CITY OF ALBUQUERQUE

November 13, 2024

RE: Velasquez Residence
8701 Glendale NE
Grading & Drainage Plan
Engineer's Stamp Date: 11/5/24
Hydrology File: B20D069

Based upon the information provided in your submittal received 11/05/2024, the Grading & Drainage Plan **is not approved** for Building Permit. The following comments need to be addressed for approval of the above referenced project.

ENGINEER'S SEAL	LOT 24 BLK 16 U 3 NAA 8701 GLENDALE AVE. NE	DRAWN BY DEM
DAVID SOULE REGISTERED PROFESSIONAL ENGINEER 14522	GRADING AND DRAINAGE PLAN	DATE 11-1-24
5/28/25	Rio Grande Engineering	8701 Glendale Ave NE, DING
DAVID SOULE P.E. #14522	ALBUQUERQUE, NM 87199 (505) 321-8099	SHEET # C1
		JOB #

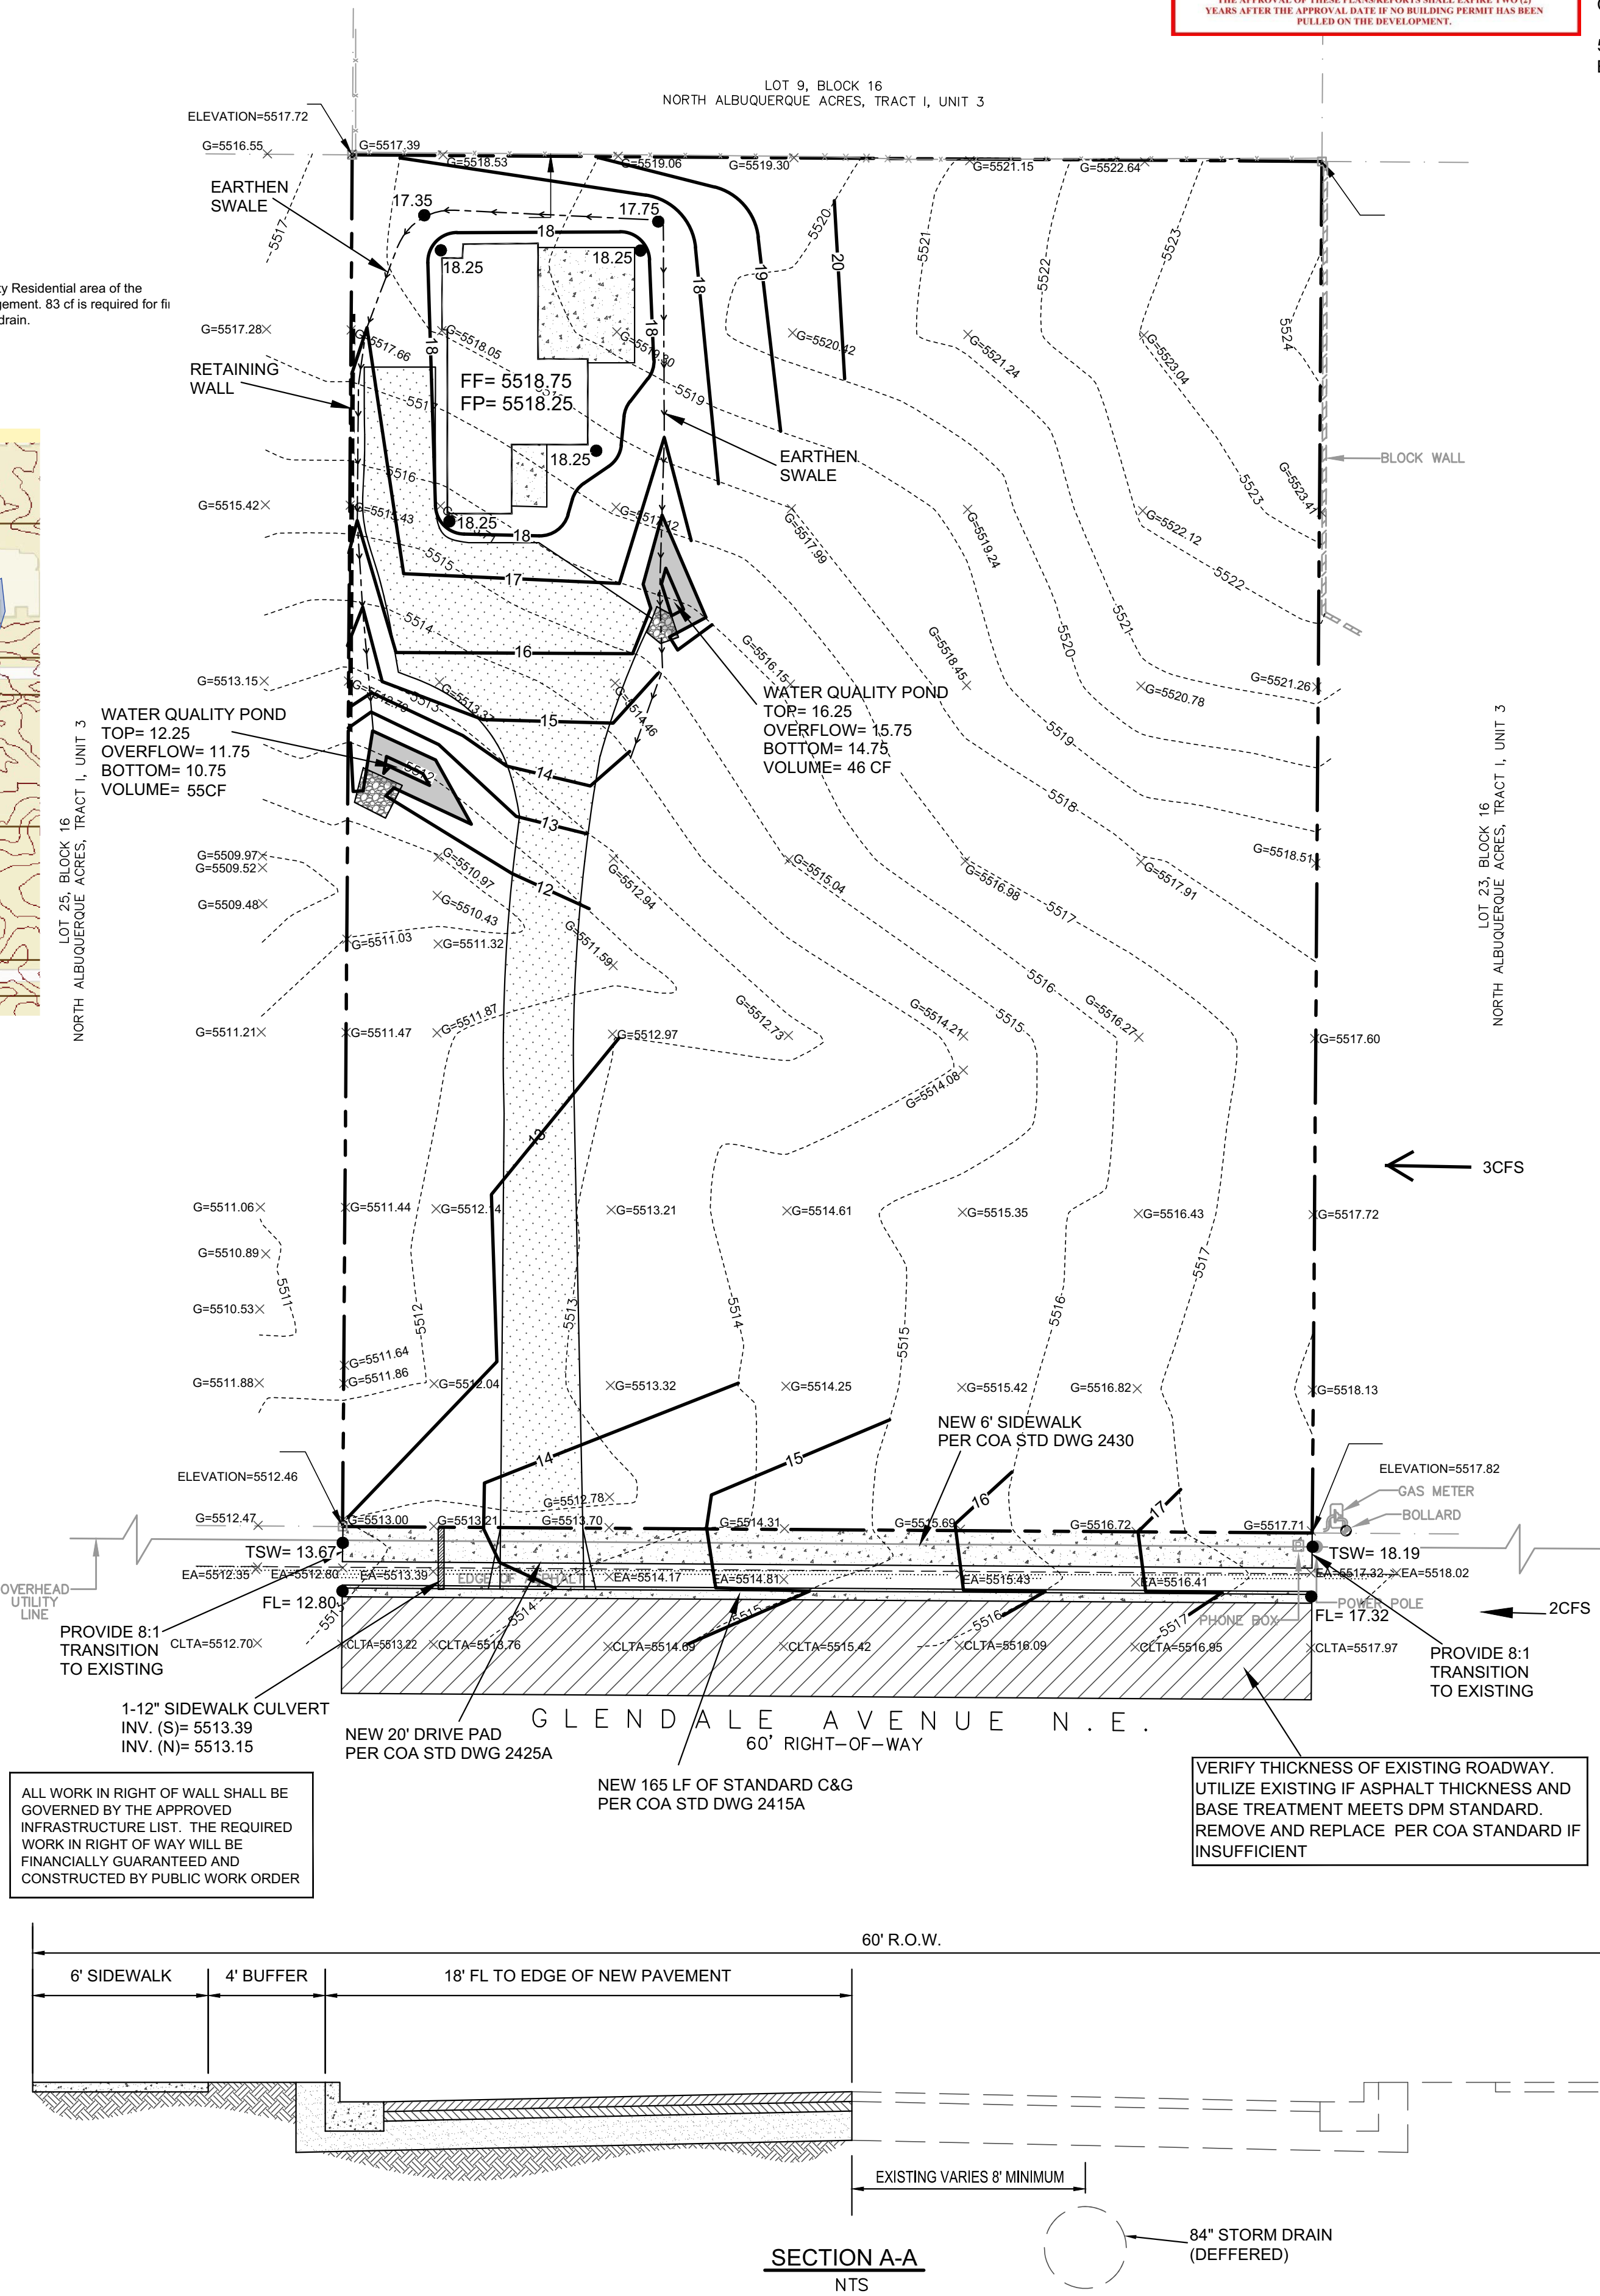
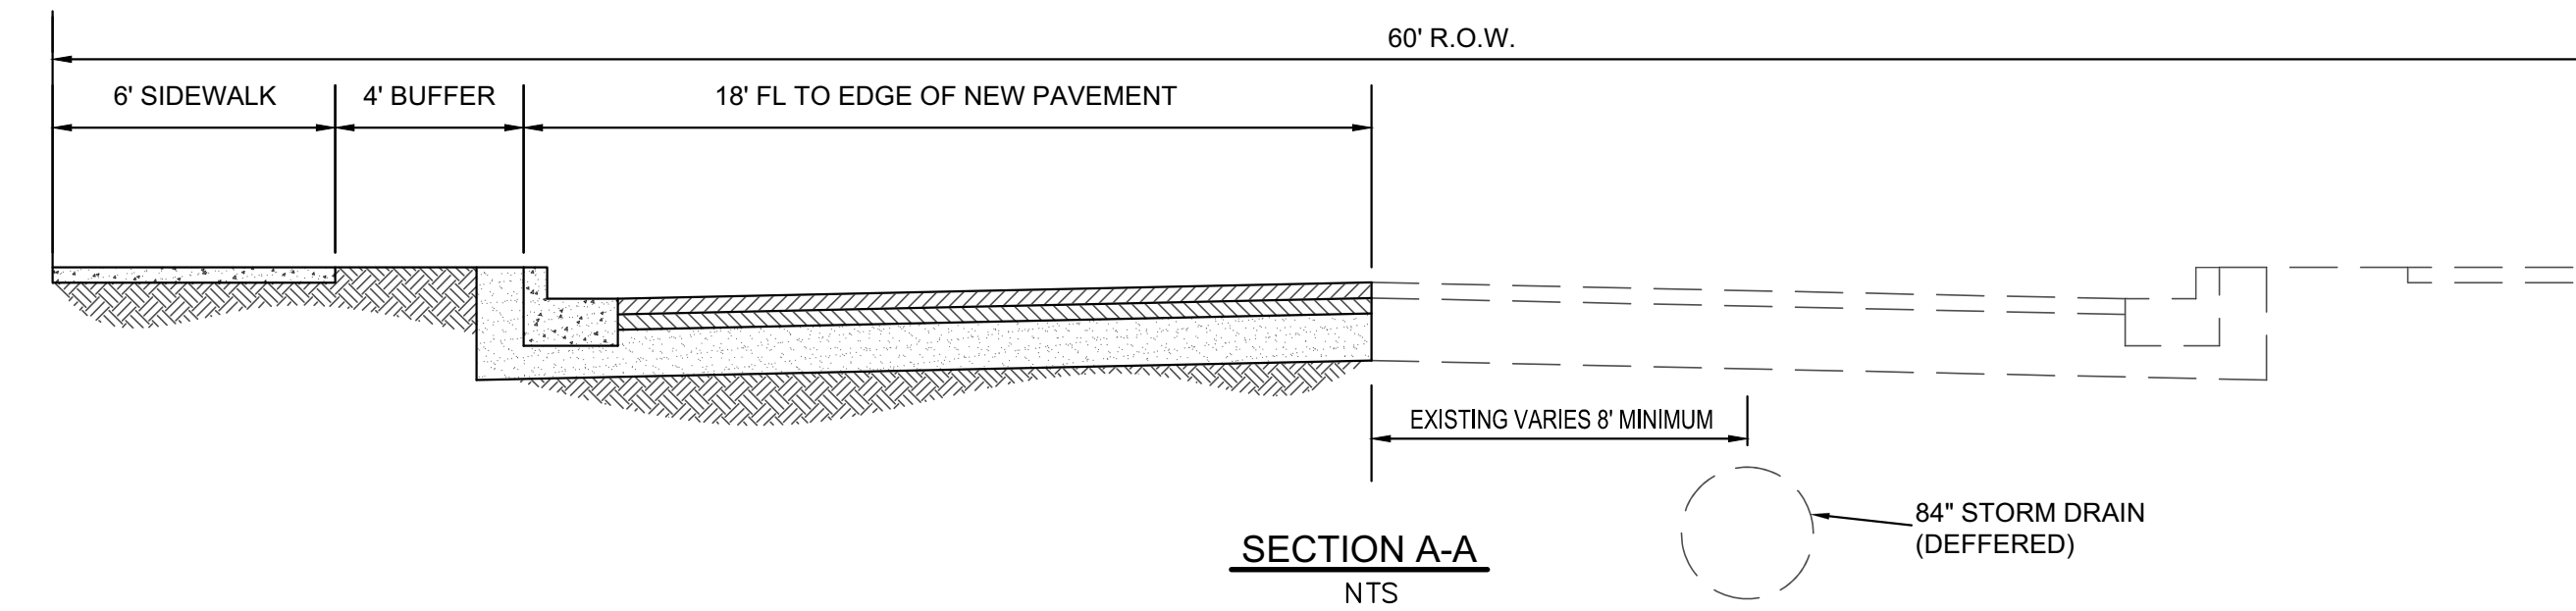
1. Per the IDO, the property owner of the property is responsible for building the adjacent half of Glendale Ave. NE to include curb & gutter, and sidewalk. The project will have to go to the Development Facilitation Team (DFT) for approval of the Infrastructure List. Also, half of an 84" storm sewer (see below) will also need to be added to the Infrastructure List. The storm sewer was called out in the NAA MDP.

2. These improvements will need to be shown on the Grading & Drainage Plan.
3. Properly showing and calculating the existing drainage that goes in the natural arroyo and Glendale from the east to the west needs to be done. This existing drainage needs to be

allowed to go through the property and can be managed somehow in the proposed development.

4. Provide management onsite for the Stormwater Quality Volume (SWQV) in accordance with the new drainage ordinance, § 14-5-2-6 (H). Please show the top and bottom of the ponds along with the volume for each pond. The onsite drainage should be directed to these ponds prior to being collected in a private unground drainage system. Please follow the DPM Article 6-12 Stormwater Quality and Low-Impact Development for the sizing calculations. To calculate the required SWQV, multiply the impervious area draining to the BMP by 0.42 inches for new development sites and 0.26 inches for redevelopment sites. The calculations of both the required and the provided volume of each BMP must be shown on the Grading and Drainage Plan. Each BMP should be labeled on the Grading and Drainage Plan with the required SWQV and associated water surface elevation and the 100-year water surface elevation. Landscaping of surface BMPs is also required to be noted on the Grading and Drainage Plan.

5. Provide the existing and proposed grades on both sides of the proposed retaining wall.
6. Provide sections through all external boundaries showing proposed retaining walls, garden walls, property/ROW lines, existing and proposed grades. In accordance with DPM Ch.22, section 5 part B, grading and wall construction near the property line may not endanger adjacent property or constrain its use.
